Your ref: SSD-50505215

Our ref: DOC24/699892

Subject: Bullawah Wind Farm (SSD-50505215)

ATTACHMENT A – BCS Assessment Summary for Bullawah Wind Farm Environmental Impact Statement (SSD-50505215)

APPENDIX B FLOOD MAPPING

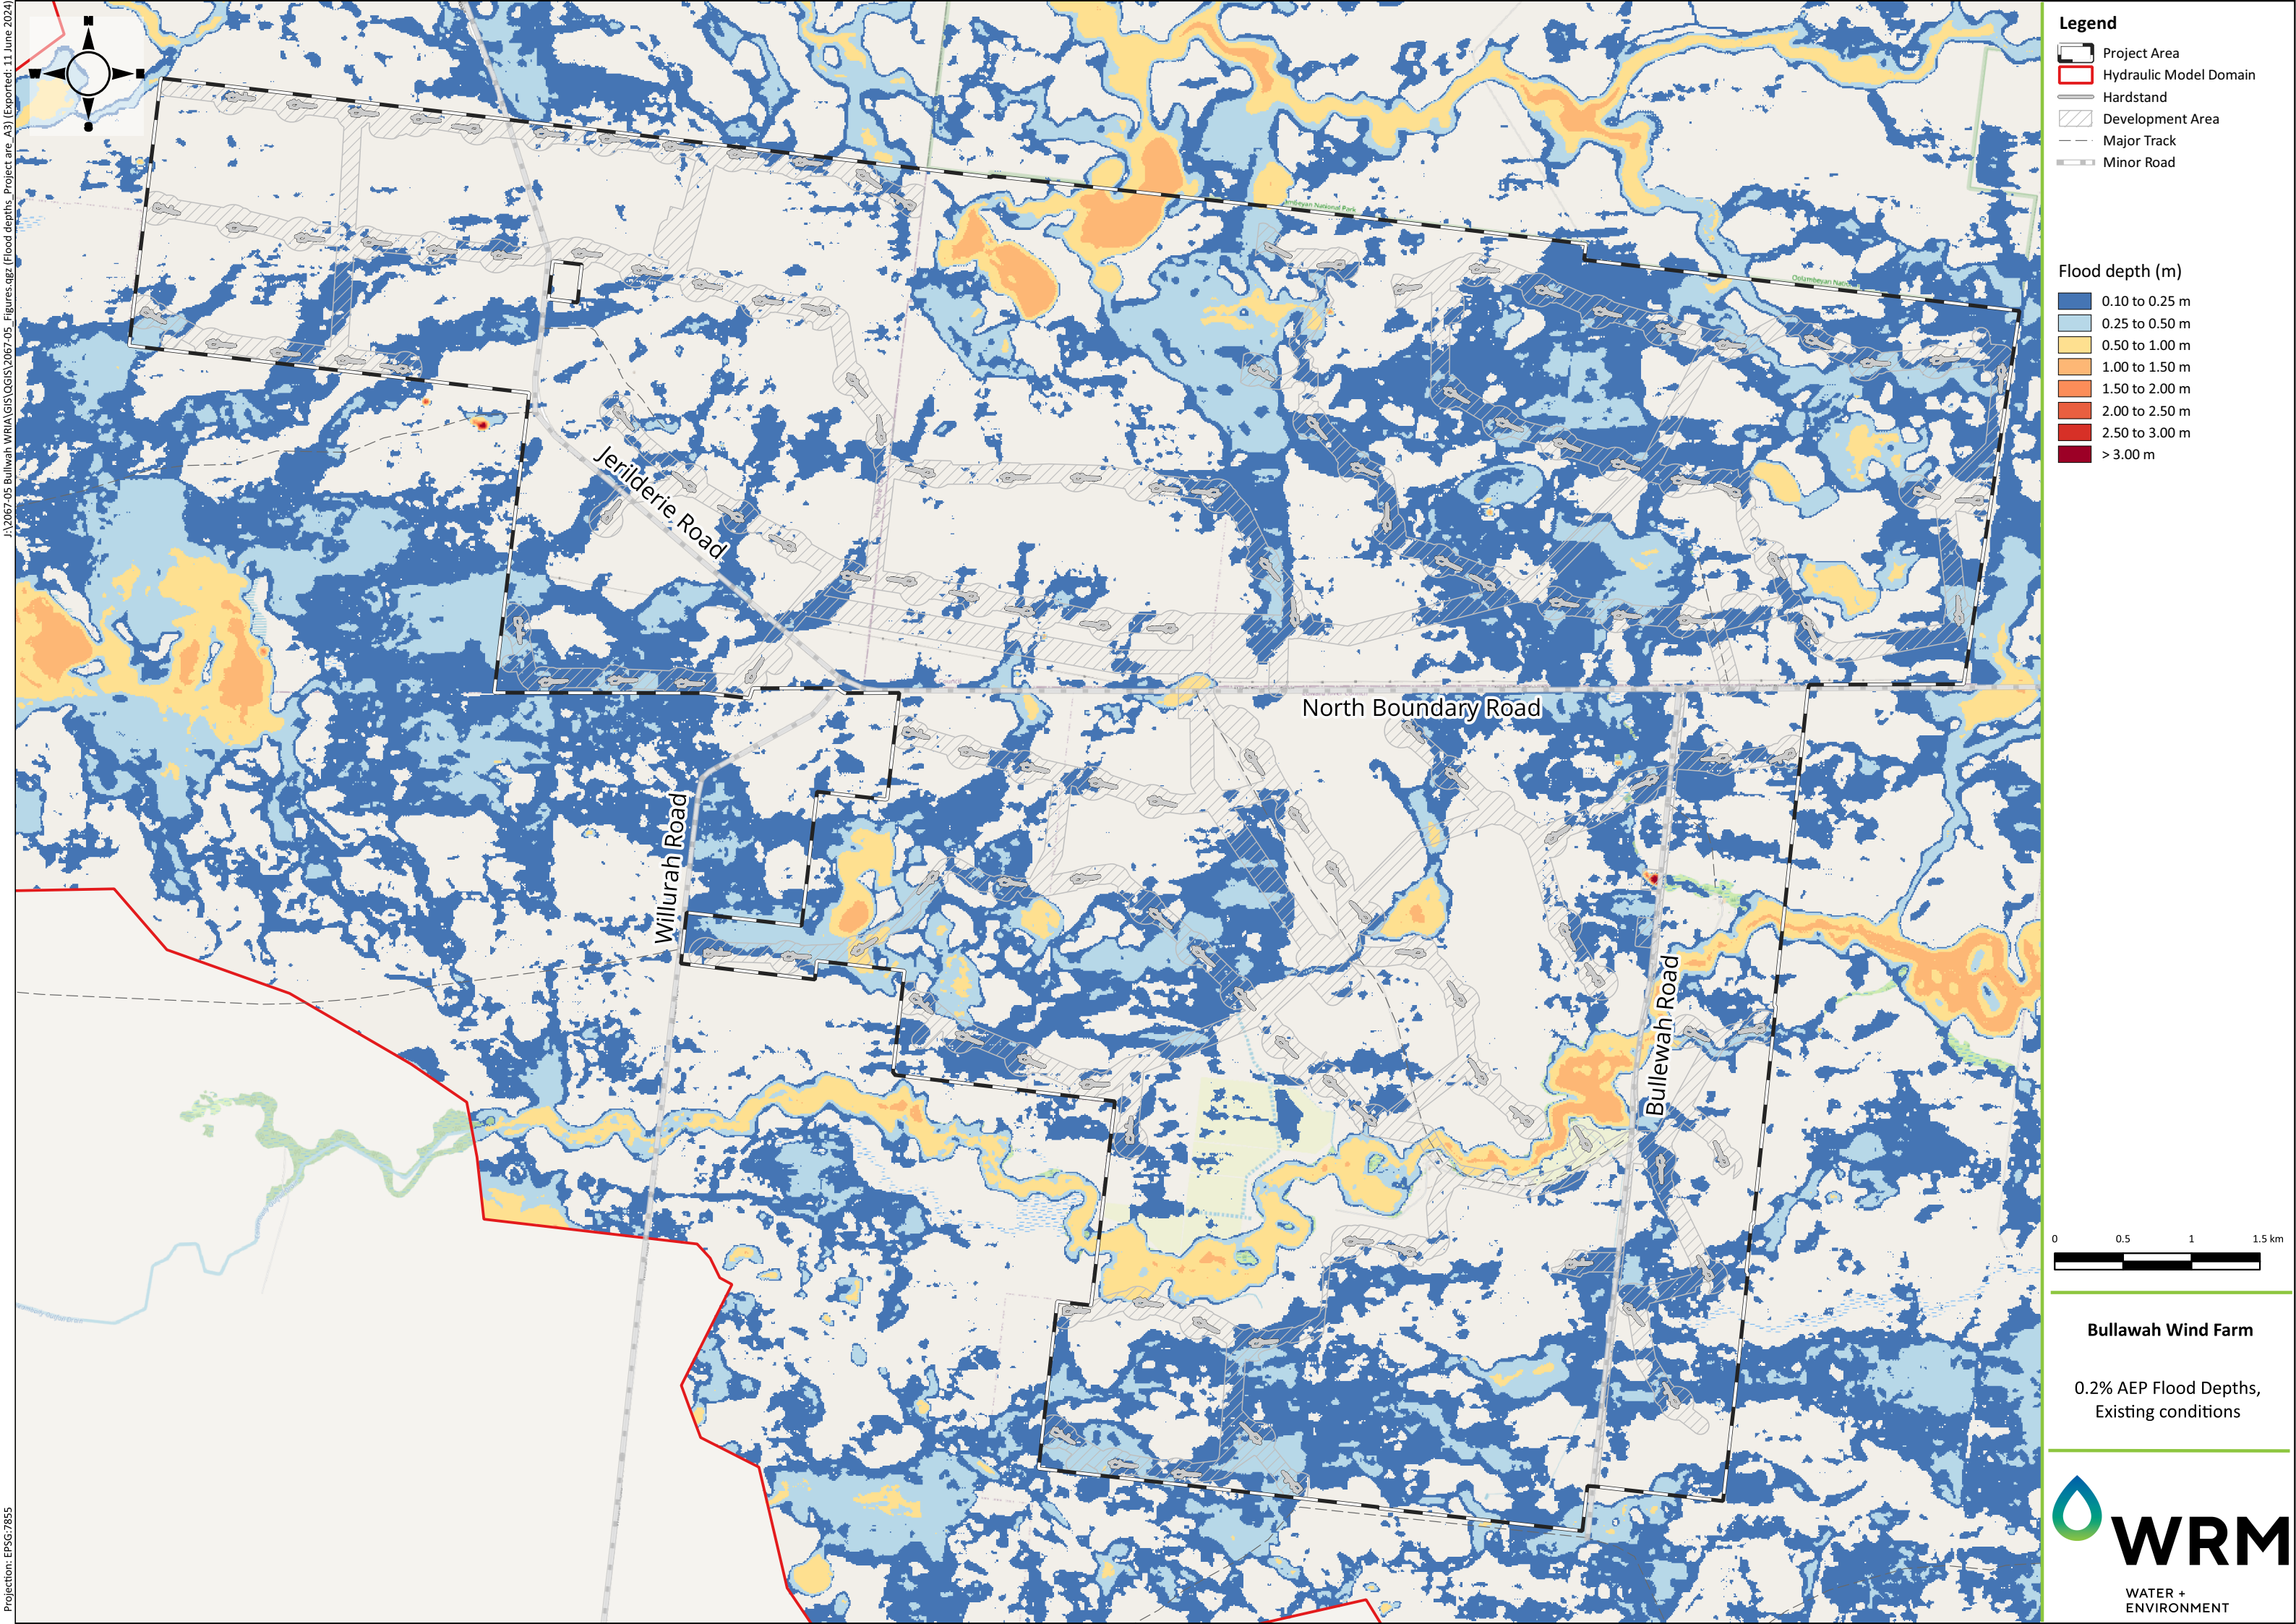
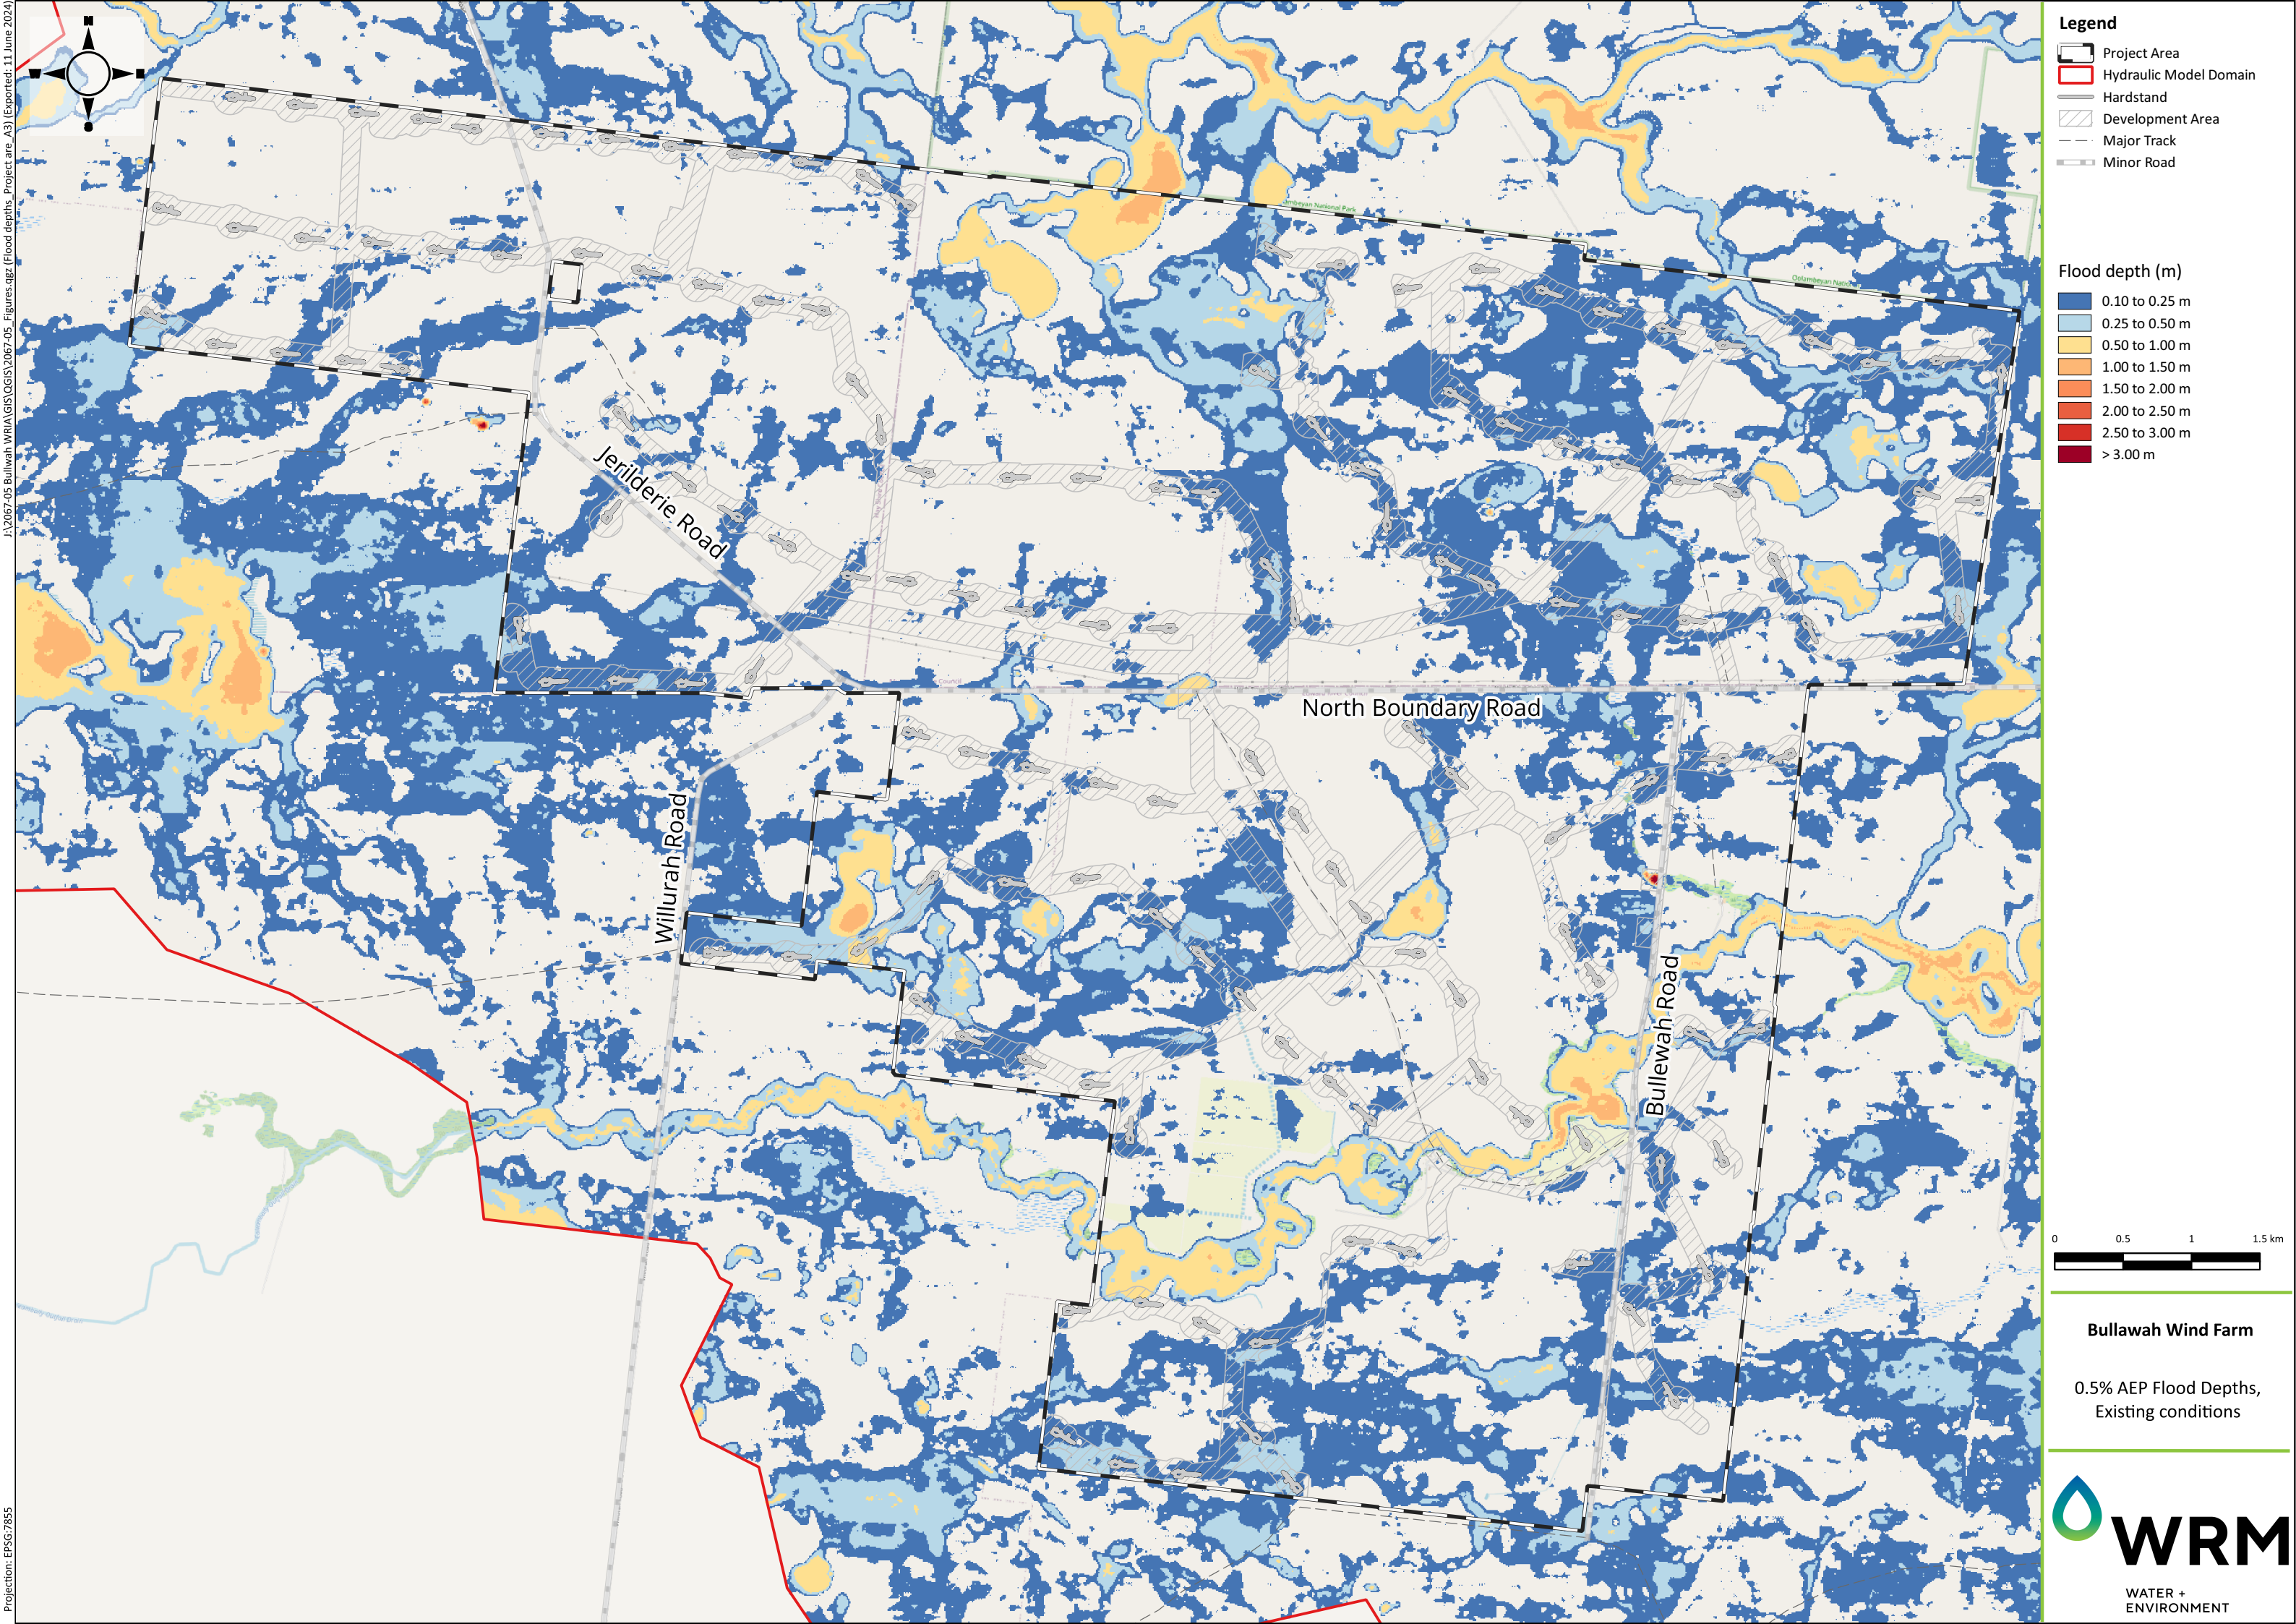
3. The flood modelling and mapping needs to include more detail of the project infrastructure to adequately inform the flood behaviour and flood risk assessment.

The Bullawah Wind Farm Project Water Resources Impact Assessment provides low-resolution mapping in its overview of the project. The mapping provides limited detail of the proposed project infrastructure, including ancillary works, in the landscape. As such, BCS is not able to determine the impact of the entire project on flood behaviour and the flood risks to the project infrastructure.

The proponent needs to complete clear and detailed mapping of sensitive and hazardous infrastructure, such as the temporary workers' accommodation, battery storage and multiple substations to allow appropriate flood risk assessment to be completed. BCS recommends that future hydraulic modelling is based on the detailed design for the project infrastructure, which will include all aspects of development, to ensure the impact of the project on flood behaviour and the flood risks to critical project infrastructure are adequately assessed.

- 3.1. Ensure future hydraulic models include the detailed design for the proposed project infrastructure to ensure the impact of the project on flood behaviour and the flood risks to critical infrastructure are adequately assessed.
